**161 SUSSEX STREET  
REDEVELOPMENT  
EXECUTIVE LOUNGE AND BAR**

**DA ACCESS REVIEW**

10th June 2015

REPORT REVISIONS		
Date	Version	Drawing No / Revision
10.06.2015	Draft	Preliminary drawings; A-DA2-0101, A-DA2-0201, A-DA2-0202, A-DA2-0203, A-DA2-0401, A-DA2-0402, A-DA2-0403, A-DA2-0404, prepared by Cox Richardson

A-DA2-0201

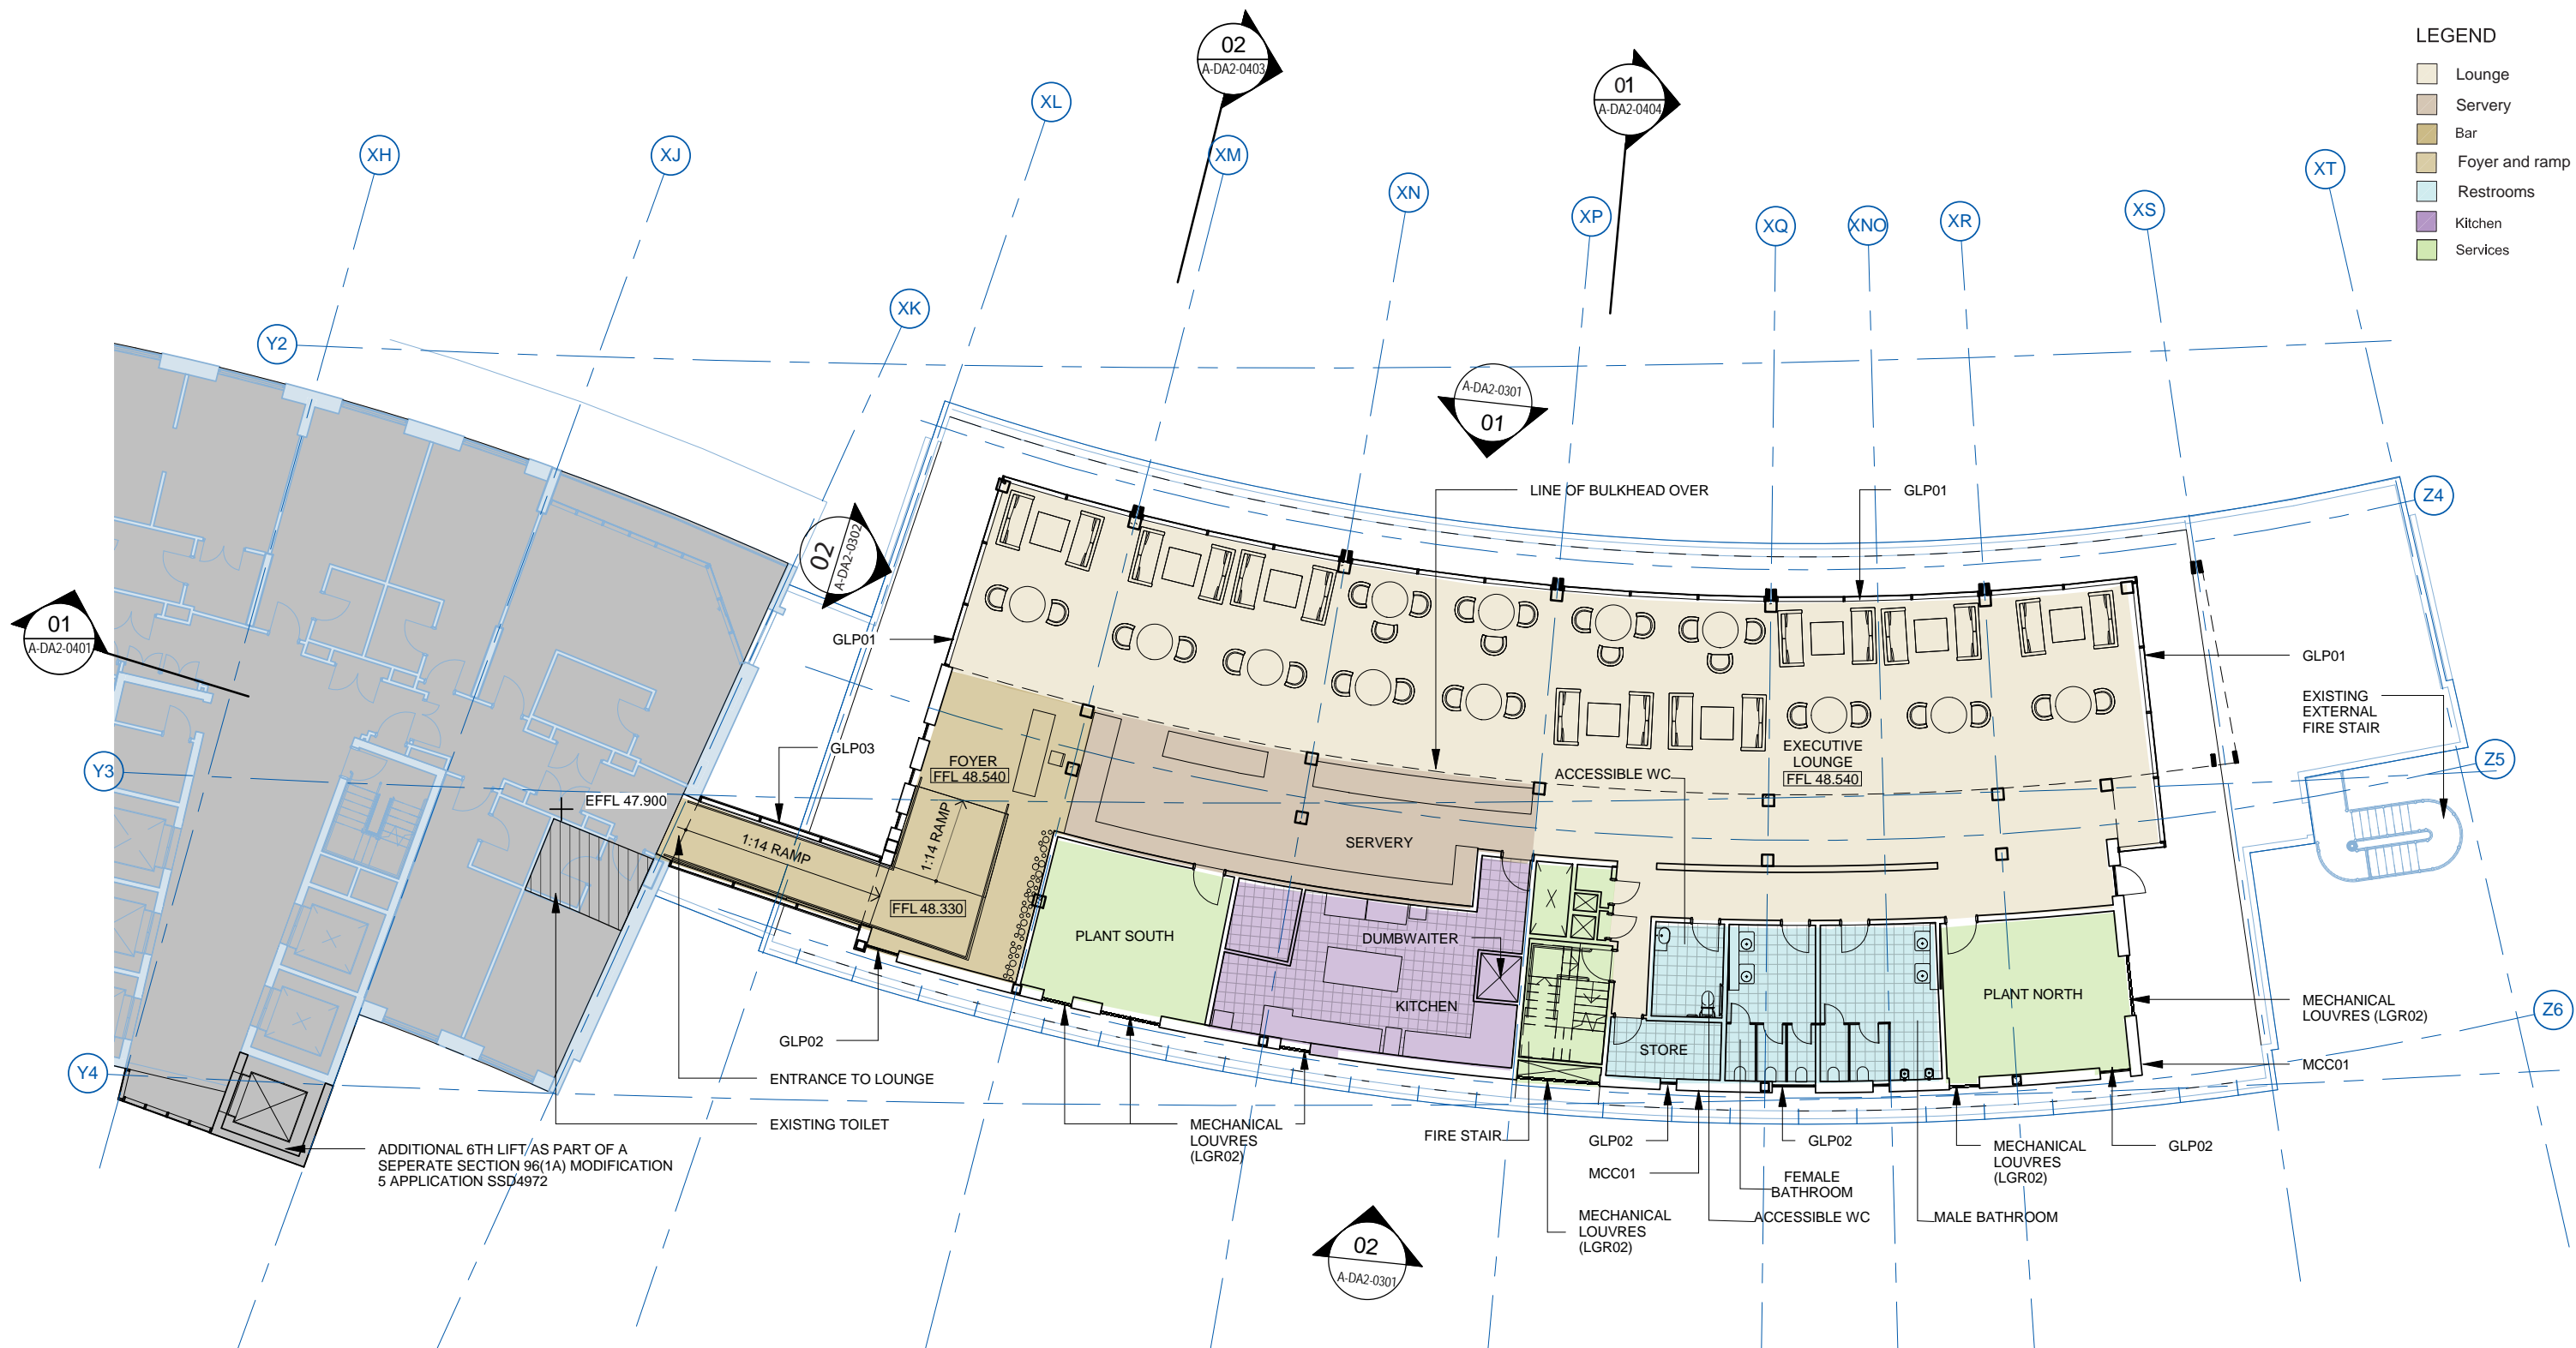
The Executive Lounge level 11 main entry is accessed via the existing south block corridor. Two 1:14 ramps with a 90 degree change in direction connect the existing part to the Lounge foyer. The ramped entry is designed in accordance with AS1428.1:2009.

- (i) Ensure ramp gradient is consistent, and ramps have a continuous handrail across the landing on each side, extending 300mm horizontally past the transition point, compliant with AS1428.1:2009.

There is generally an open plan layout and the Foyer areas provide 1800mm minimum width which will allow 2 wheelchair users the ability to pass each other travelling in the opposite direction. The corridor outside the sanitary facilities has 1200mm min. clear width in accordance with the circulation space requirements set out in the City of Sydney Access Development Control Plan, however needs minor increase to enable a wheelchair user to turn 90 degrees to enter and for door circulation space to the accessible toilet.

- (i) Ensure corridor outside sanitary facilities has 1500mm min. clear width, compliant with AS1428.1:2009.
- (ii) Ensure common area floor surfaces are suitably slip resistant and traversable by a wheelchair or walking frame, compliant with AS 1428.1:2009 and HB197/AS4856 (wet pendulum method).
- (iii) Furniture in the lounge to not protrude into the minimum (1200mm) unobstructed accessible path of travel to comply with AS1428.2:1992 and the City of Sydney Access Development Control Plan.

Drawing Title:
EXECUTIVE BAR - LEVEL 12

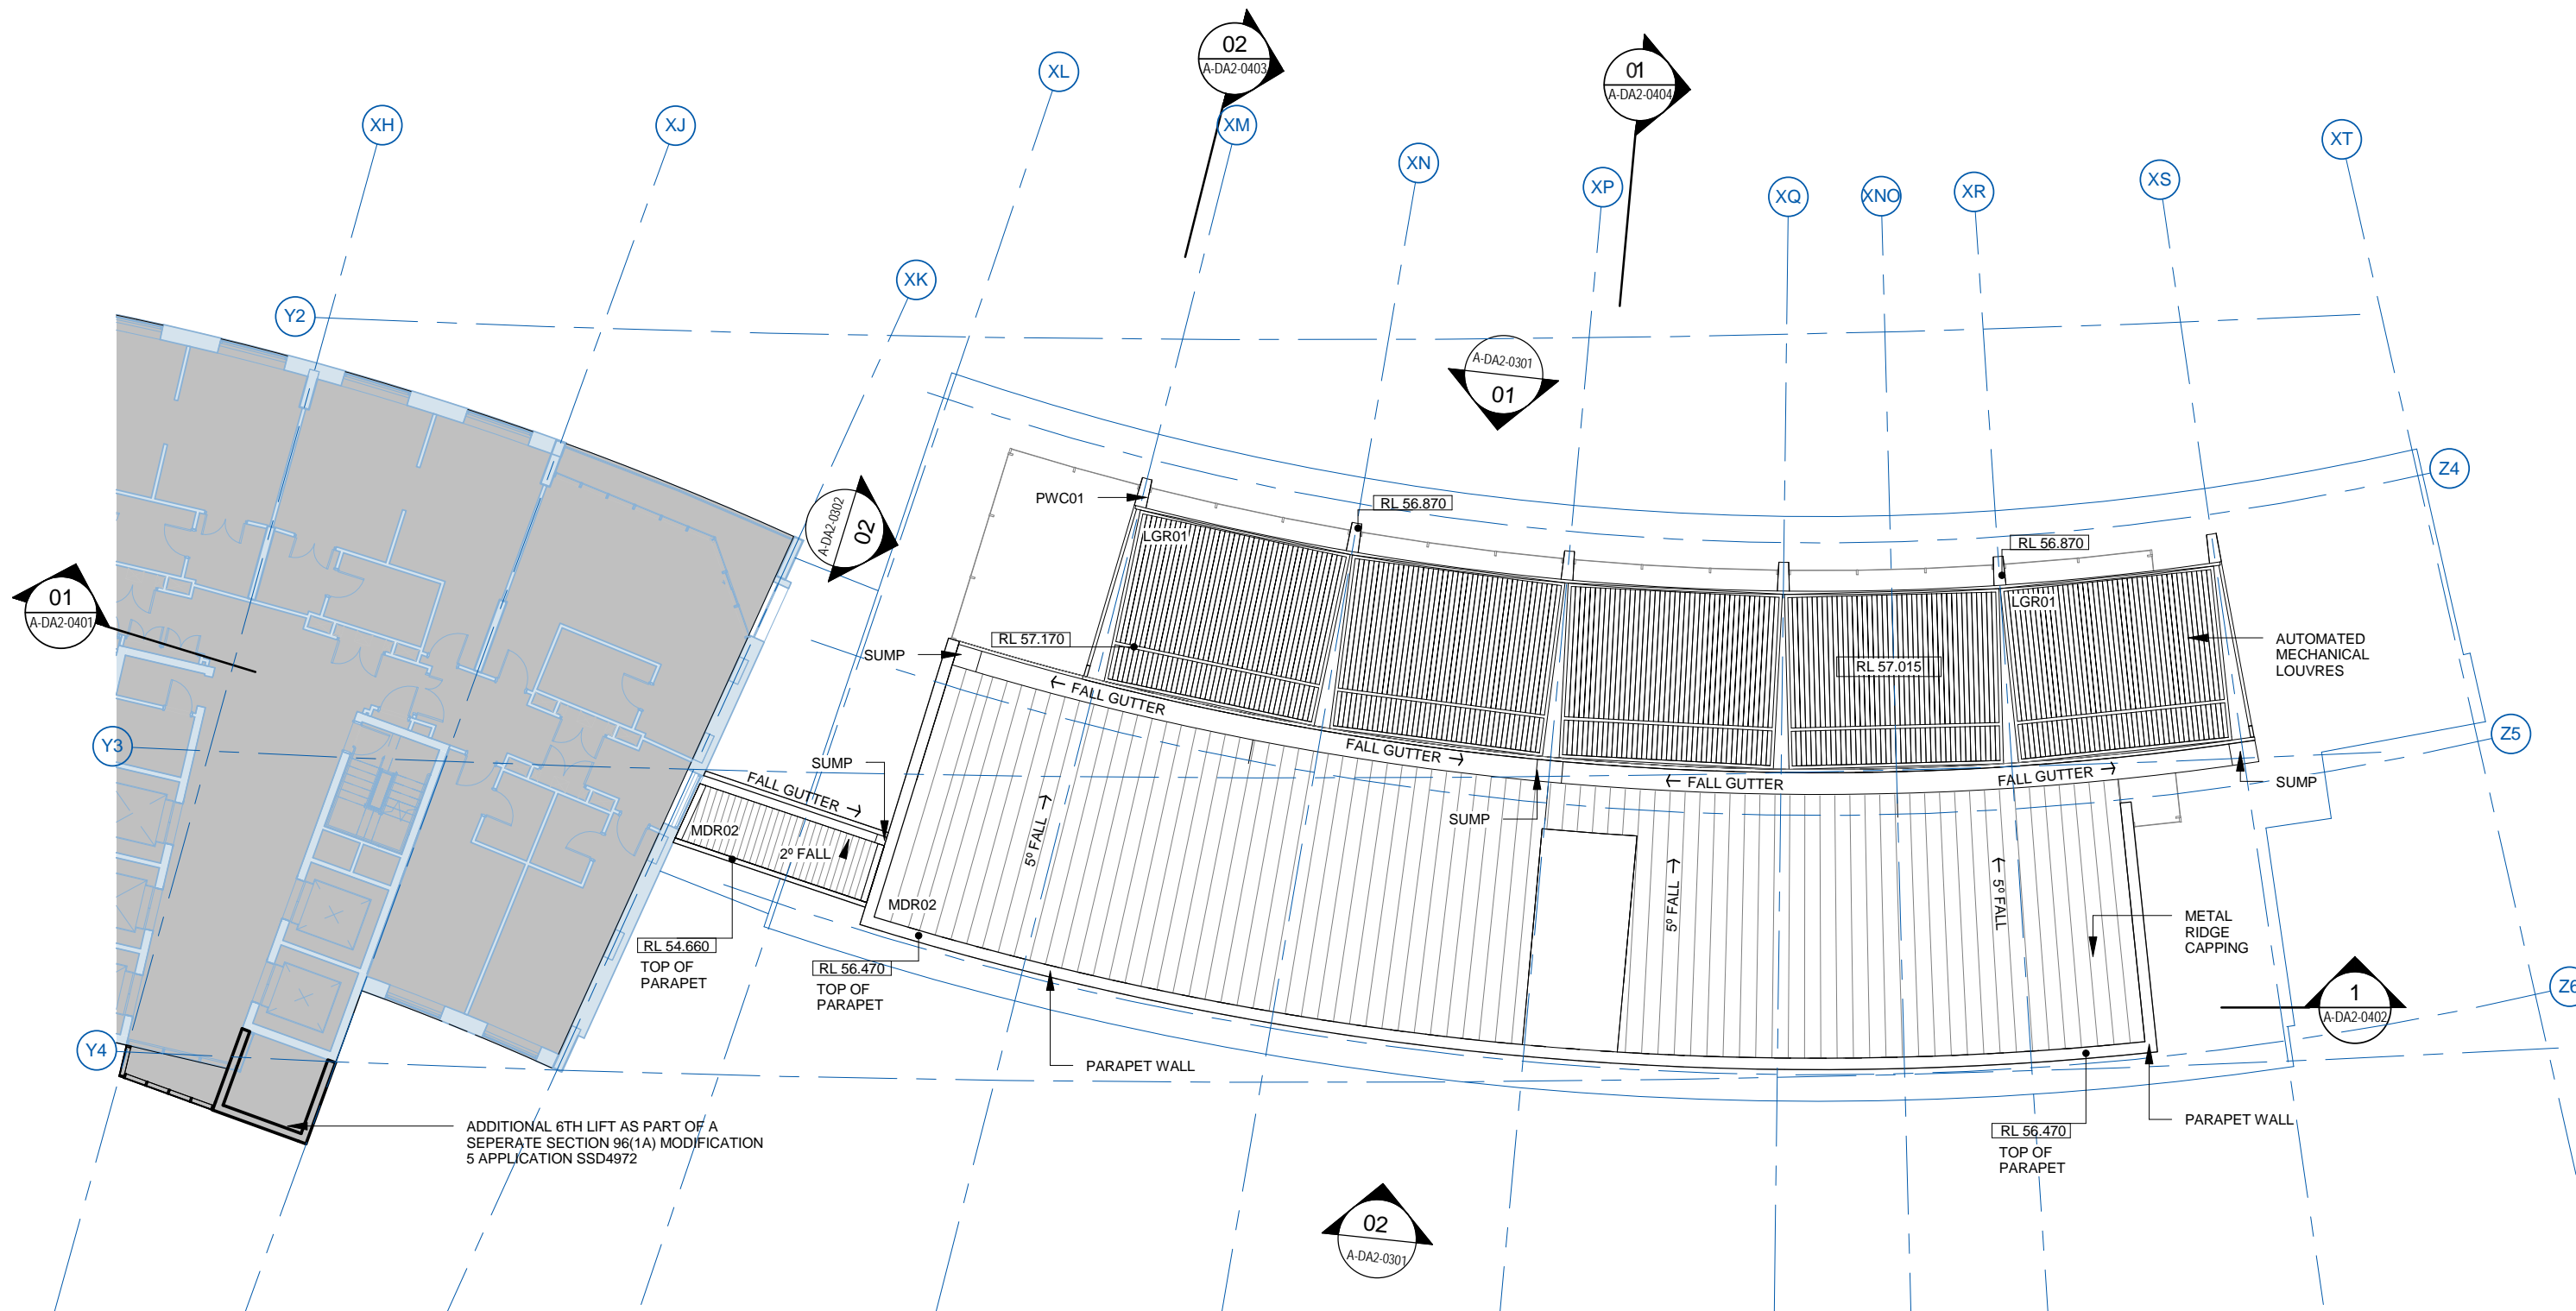
The Executive Bar at level 12 is connected to the existing hotel south by three 1:14 ramps with a 90 degree change in direction. The ramped entry is designed in accordance with AS1428.1:2009.

In general, the main paths of travel and corridors throughout the bar have suitable clear widths that will allow appropriate turning and passing areas in accordance with DDA Premises Standards and AS1428.1:2009. The corridor outside the sanitary facilities meets the 1200mm clear width in accordance with the circulation space requirements set out in the City of Sydney Access Development Control Plan however needs minor increase to enable a wheelchair user to turn 90 degrees to enter and for door circulation space to the accessible toilet.

- (i) Ensure corridor outside sanitary facilities has 1500mm min. clear width, compliant with AS1428.1:2009.
- (ii) Ensure common area floor surfaces are suitably slip resistant and traversable by a wheelchair or walking frame, compliant with AS 1428.1:2009 and HB197/AS4856 (wet pendulum method).
- (iii) Fixed furniture / Furniture in the bar to not protrude into the minimum (1200mm) unobstructed accessible path of travel to comply with AS1428.2:1992 and the City of Sydney Access Development Control Plan.

The Executive Bar has glazed sliding panels / concertina doors opening out on to the rooftop bar deck.

- (i) Ensure all new doorways (hinged and sliding) provide at least 850mm clear width (generally a 920mm door leaf) with suitable door circulation space, compliant with AS1428.1:2009.
- (ii) Sliding / concertina doors to the Rooftop Bar on Executive Bar Level 12 should be easy to grip and be easy to operate with limited force. Where concertina doors are used, provide an alternative accessible hinged door adjacent, compliant with AS1428.1:2009.
